From:
Sent: 01 January 2024 10:54
To: DCAdmin
Subject: Planning application 2023/93348

Concerning planning application 2023/93348.

Proposed Plans and
Elevations

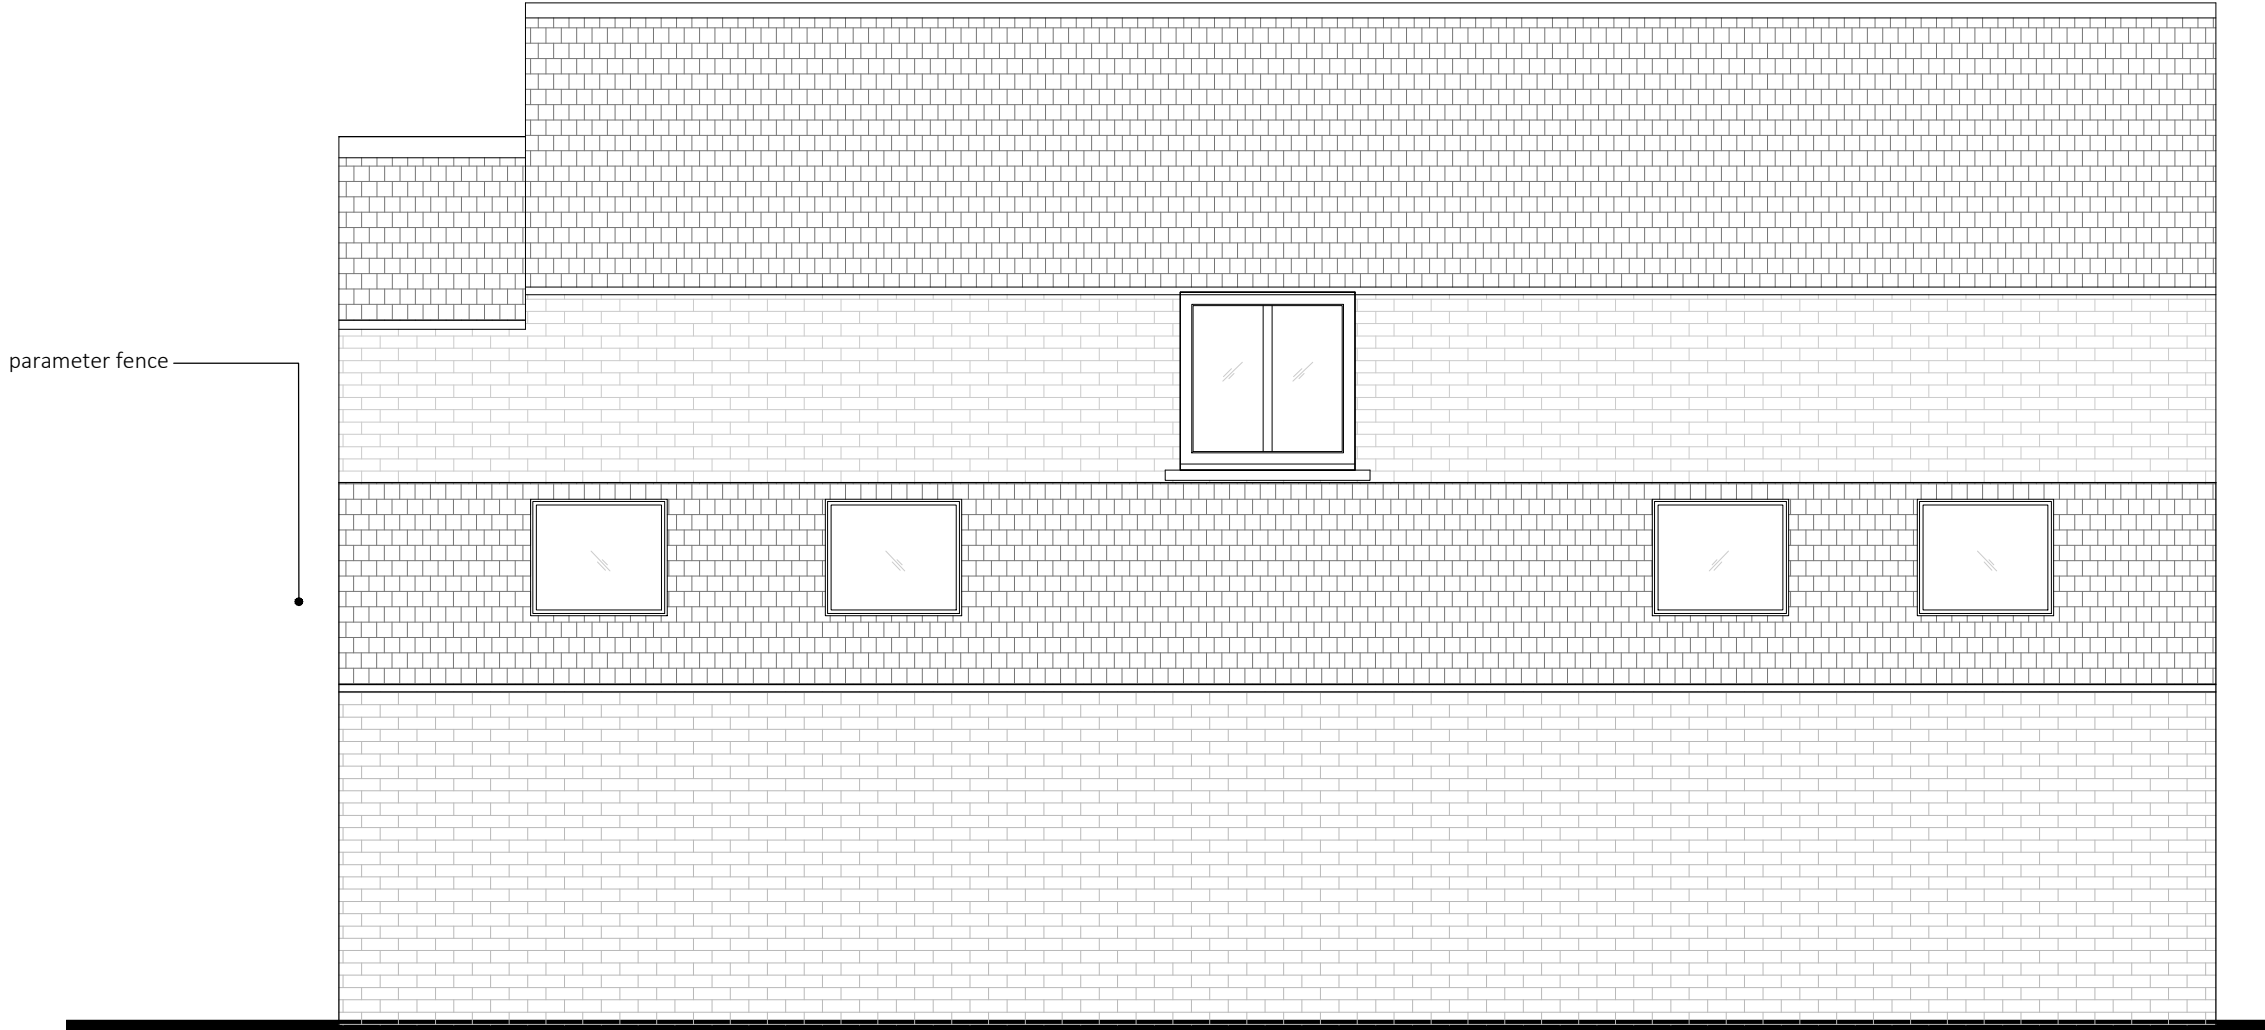
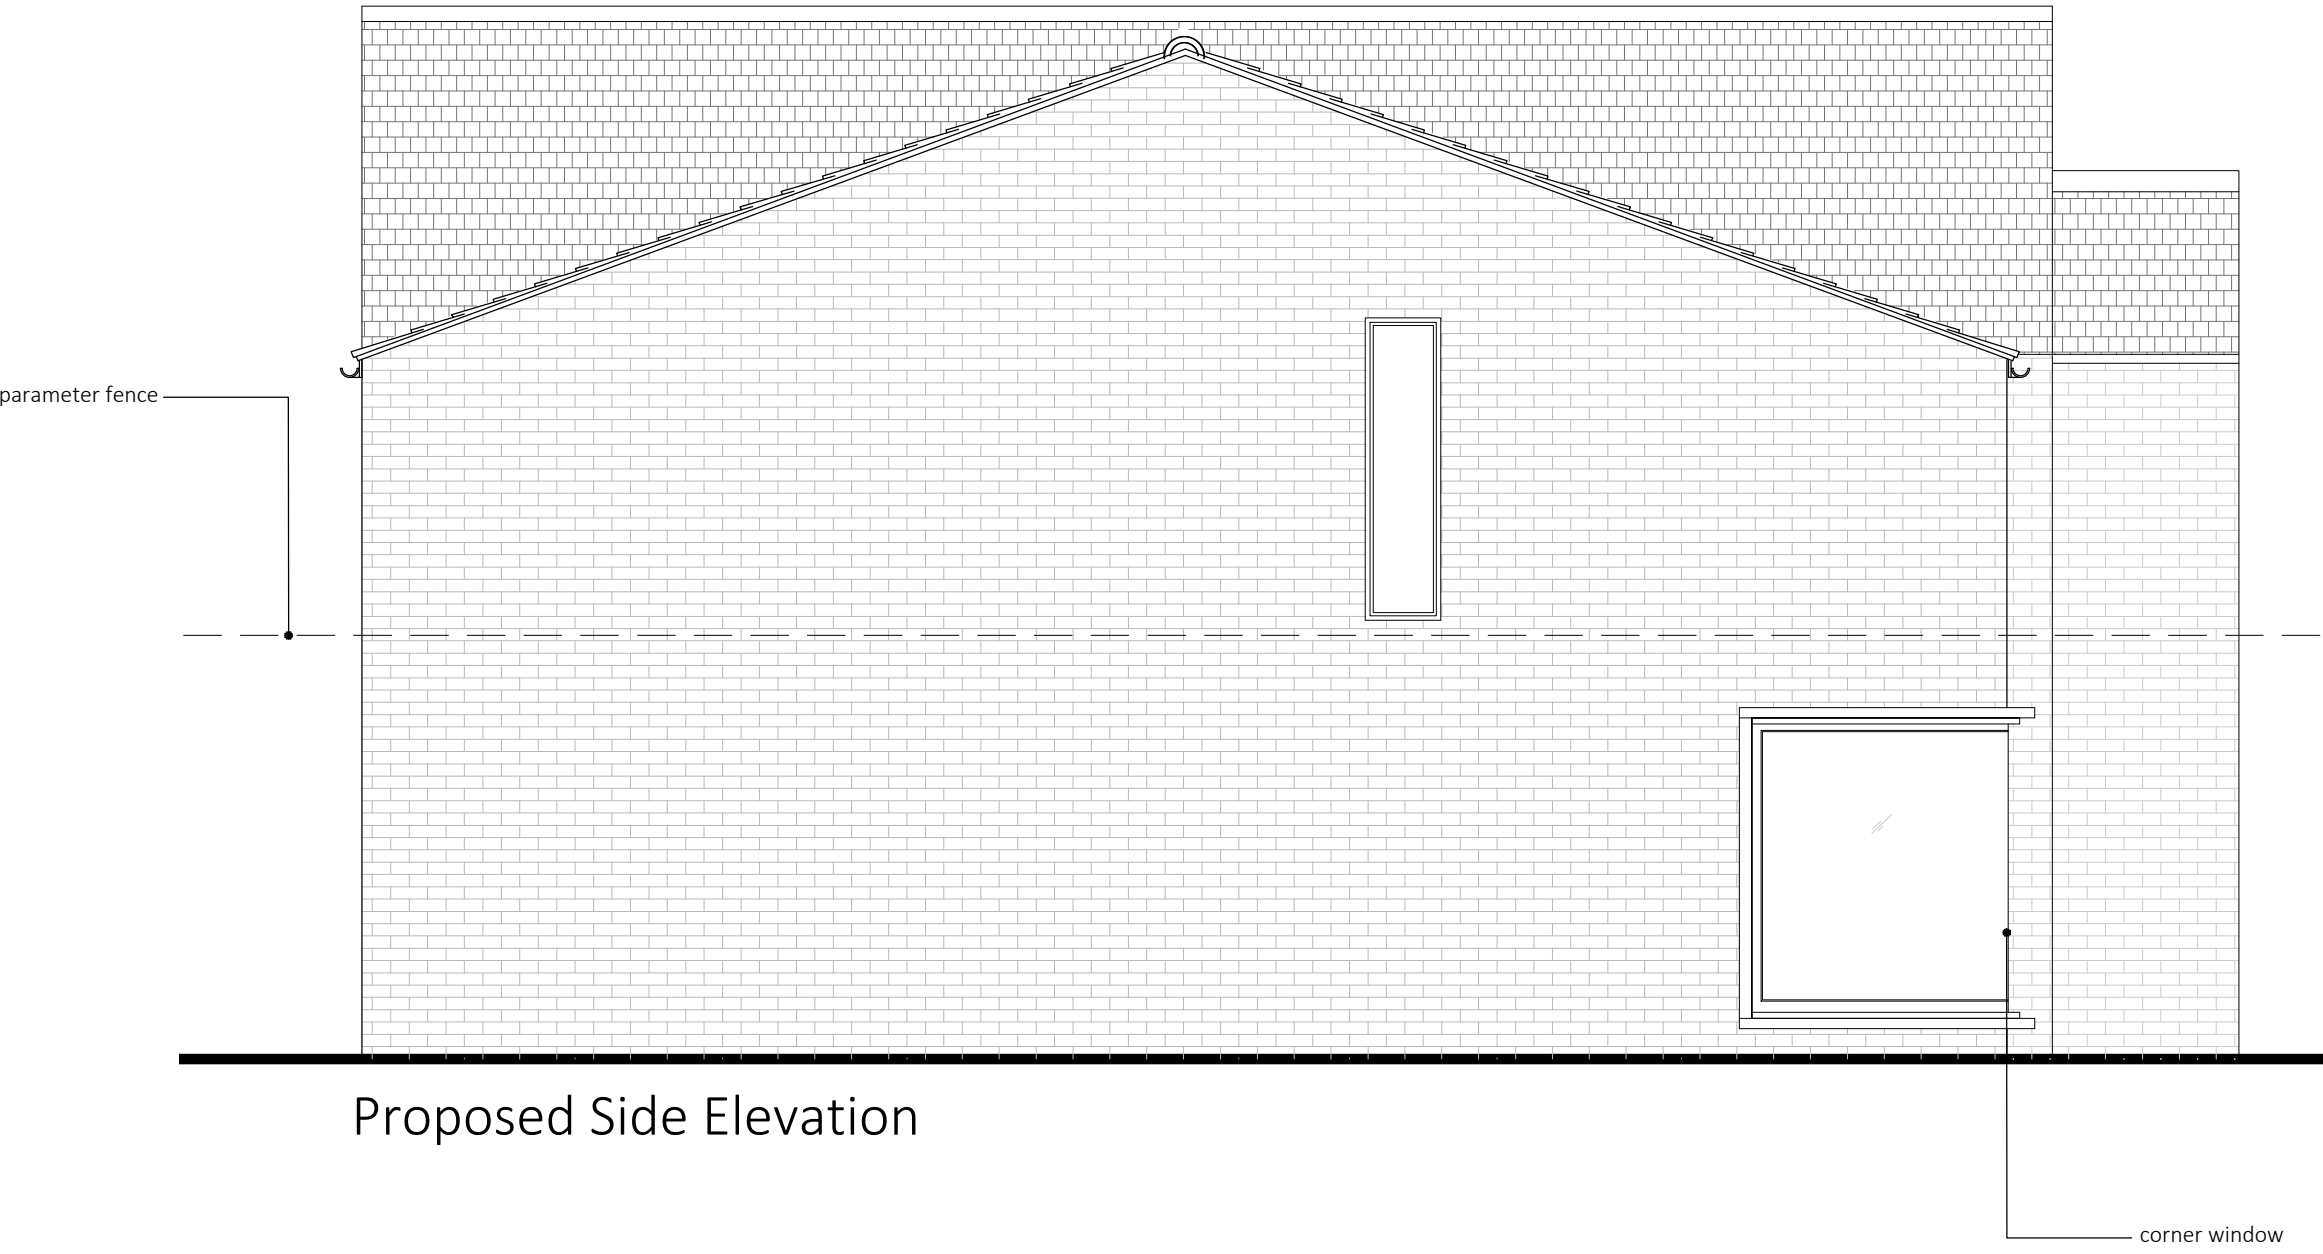
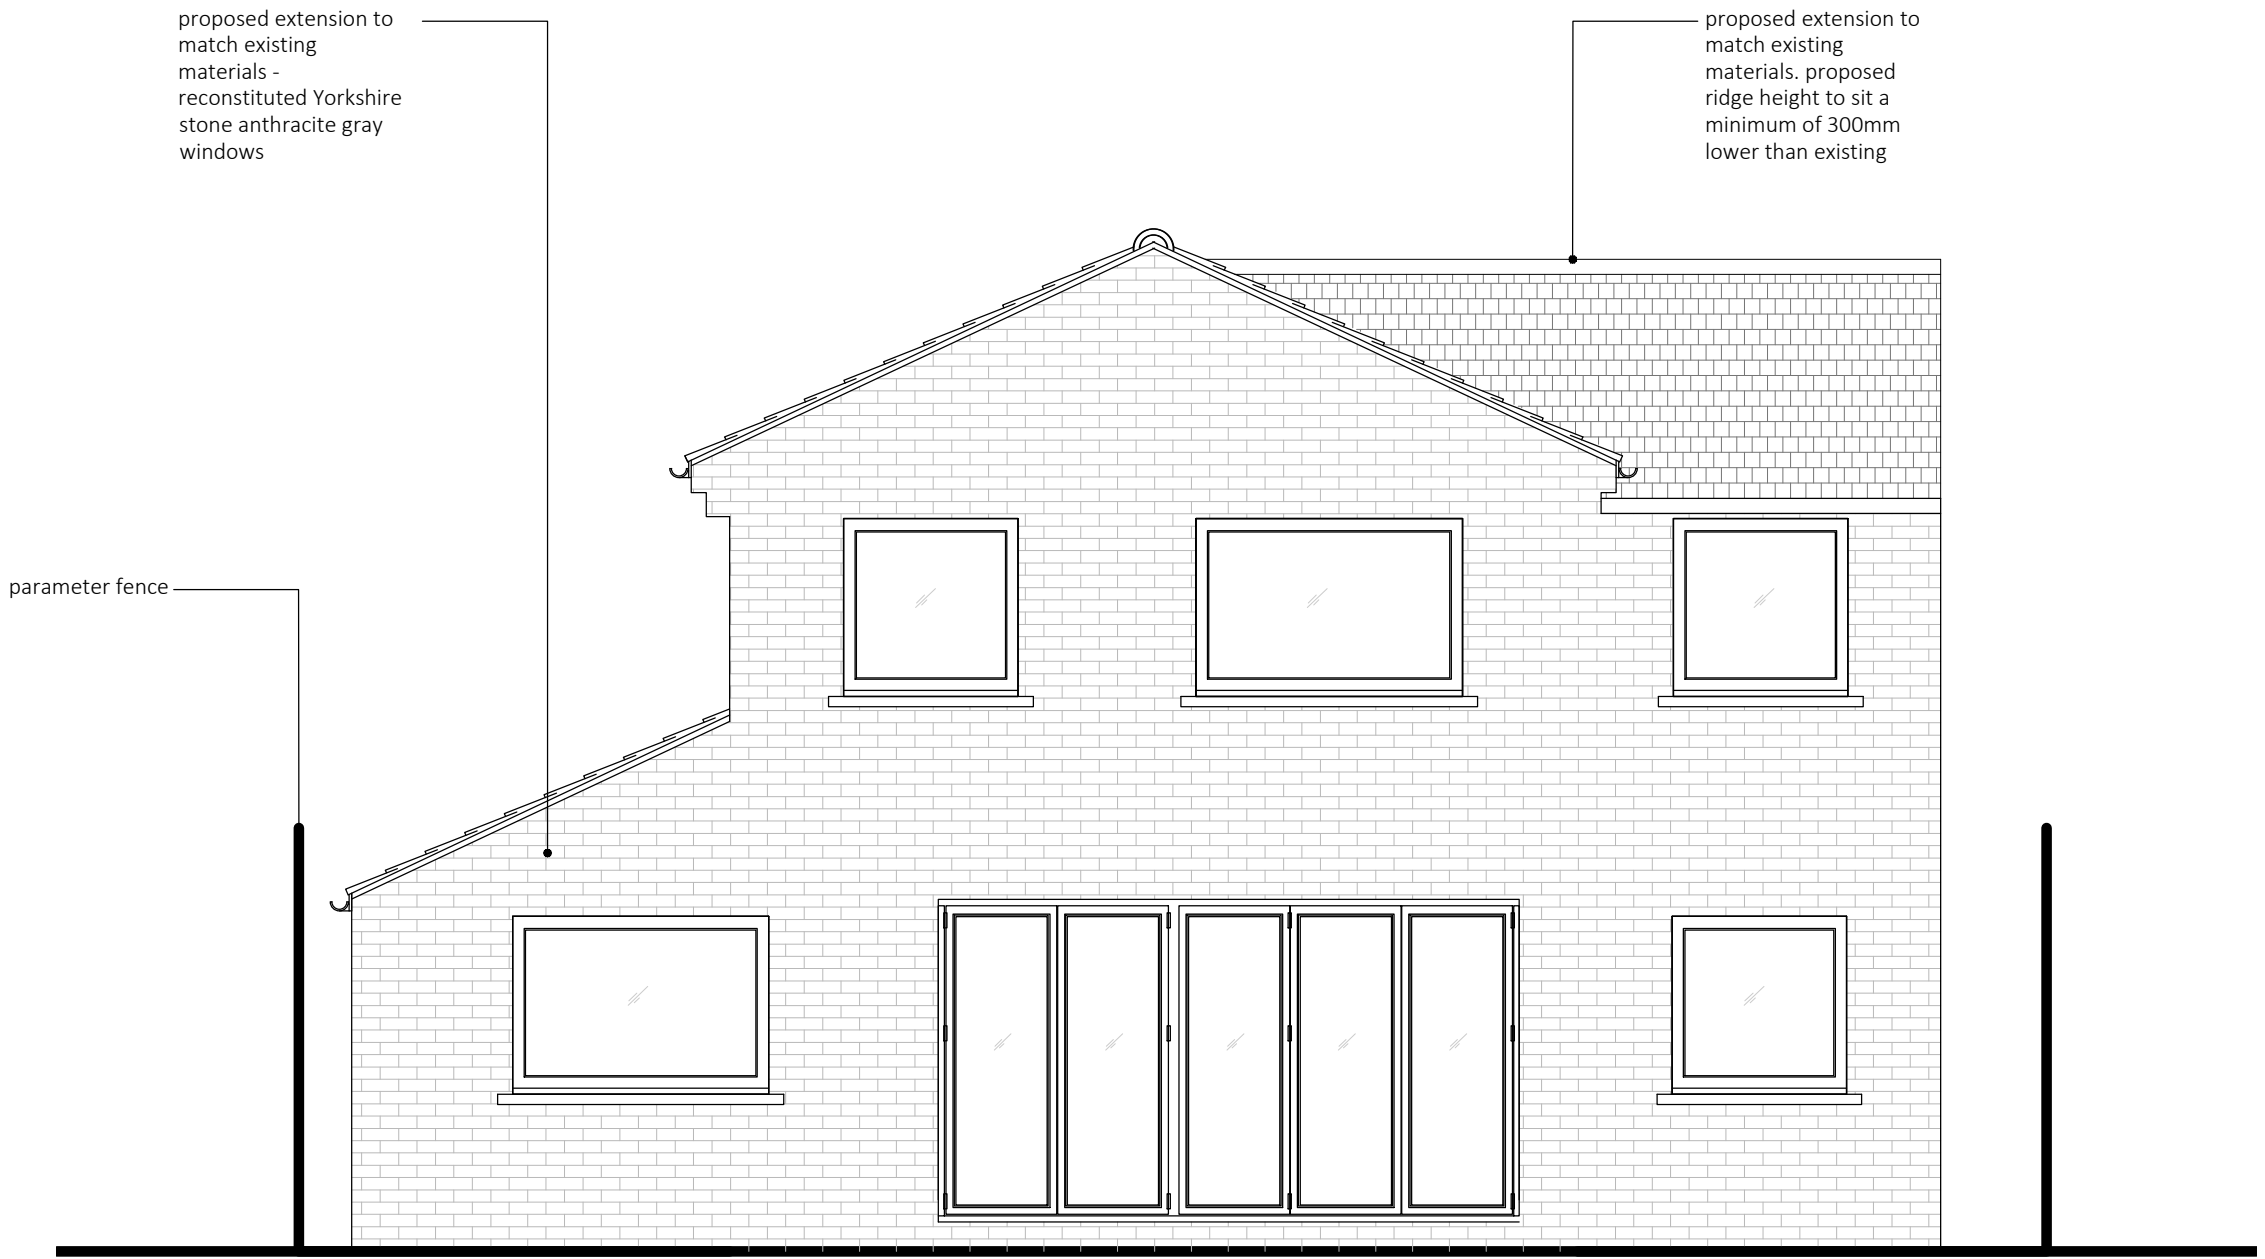
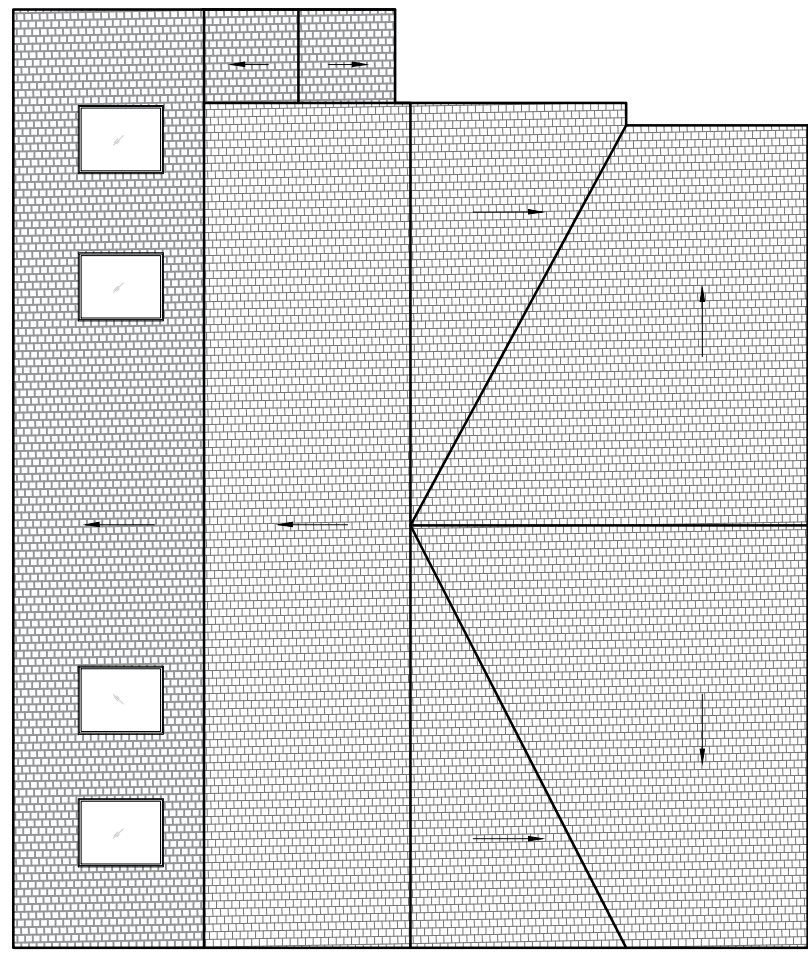
We have concerns regarding the building extensions proposed at 22 Goldcrest Court. This will be right up close to the boundary of our premises. This will give problems of access during the building and throughout the lifetime of the extensions. Fitting the roof will be a problem and any future maintenance on the roofs, gutters, windows and walls will not be possible without access to our garden and possible erection of scaffolding and ladders.

We are also concerned that during building there could be damage to our boundary fence and its foundations due to its proximity.

There will also be a small loss of sunlight to our house and garden due to the increased height of the gable over the front door.

We feel that this extension proposal is ill advised as there will be no external access to their garden. The garden space at the rear provides plenty of space for extensions.
